Response to Submissions SSD 6674 Environmental Impact Statement

The University of New South Wales

Biological Sciences Project

Submitted to Department of Planning and Environment
On Behalf of University of New South Wales

1 EAST ELEVATION - FROM BOTANY STREET
SCALE 1 : 200

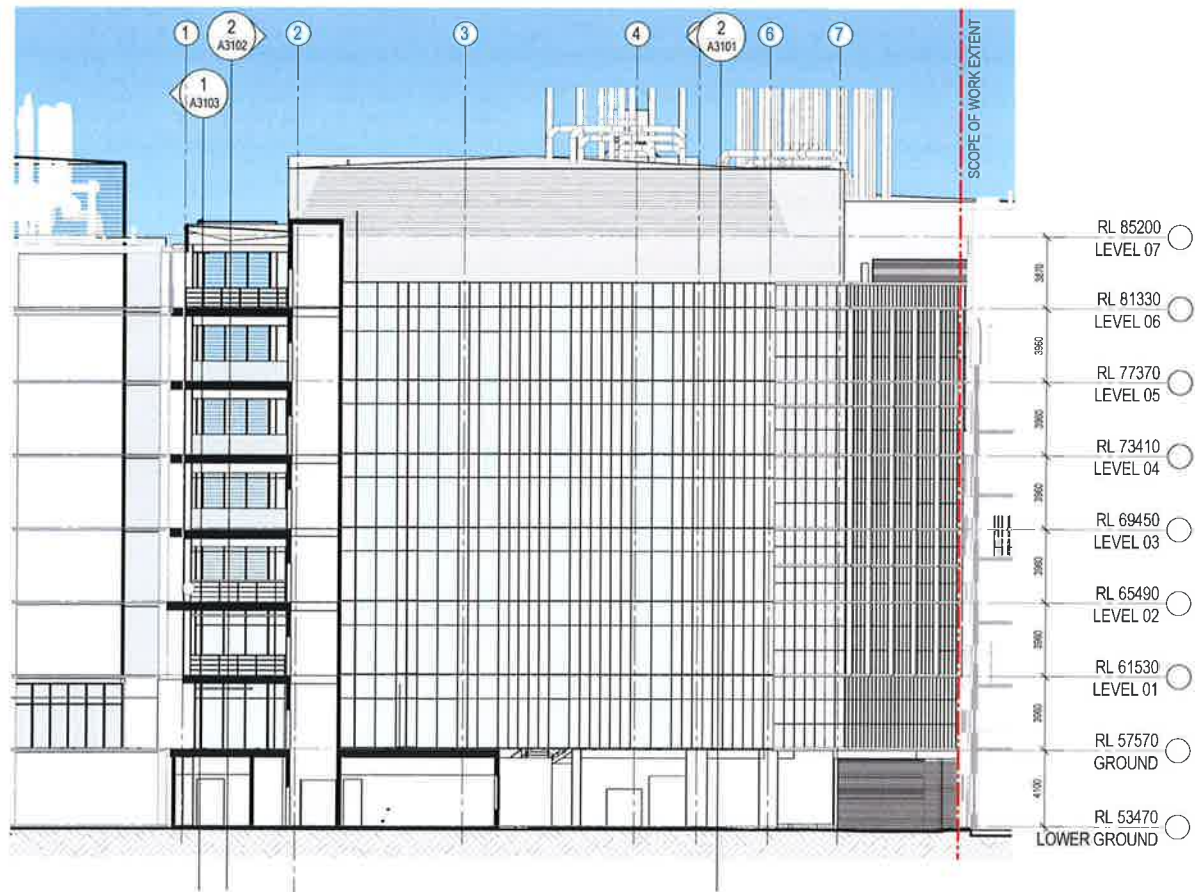
The DPE have requested further consideration should be given to the activation of the south eastern corner of the site or the treatment of this façade to provide an improved visual setting given Gate 11 is a designated entrance/exit to the campus and the eastern end of University Mall.

The form and design of the south eastern elevation responds to the function nature of the building use as a research building, containing laboratory and teaching spaces. The design of this façade however, uses a range of colour and materials to create a play of scale and texture, resulting in patterns being set within the modular grid. The reveal back to the ground level student spaces, along with the landscaped setback, draws an expression of the campus onto the edge of the precinct.

The south east corner of the building facade has been purposely designed to discourage pedestrian activity around Gate 11 to achieve the pedestrian-vehicular separation, and to 'shelter' the services zone when viewed from the street. Notwithstanding, the design of the building at this corner has been carefully considered with regard to its presentation and interface with Botany Street discussed below.

Given the clear rationale above, the ground floor design, and landscaping arrangement, in the south eastern corner and Botany Street particularly, have been redesigned (see attached Architectural Plans (**Appendix B**) and Landscape Plan (**Appendix E**). The design responds to comments made by Council to give further consideration to the presentation and legibility of this frontage.

The proposed arrangement now includes an additional path through lawn on lower terrace and retention of existing Brick wall to the Botany Street boundary provide greater legibility of the separation between primarily pedestrian and vehicle entry points.
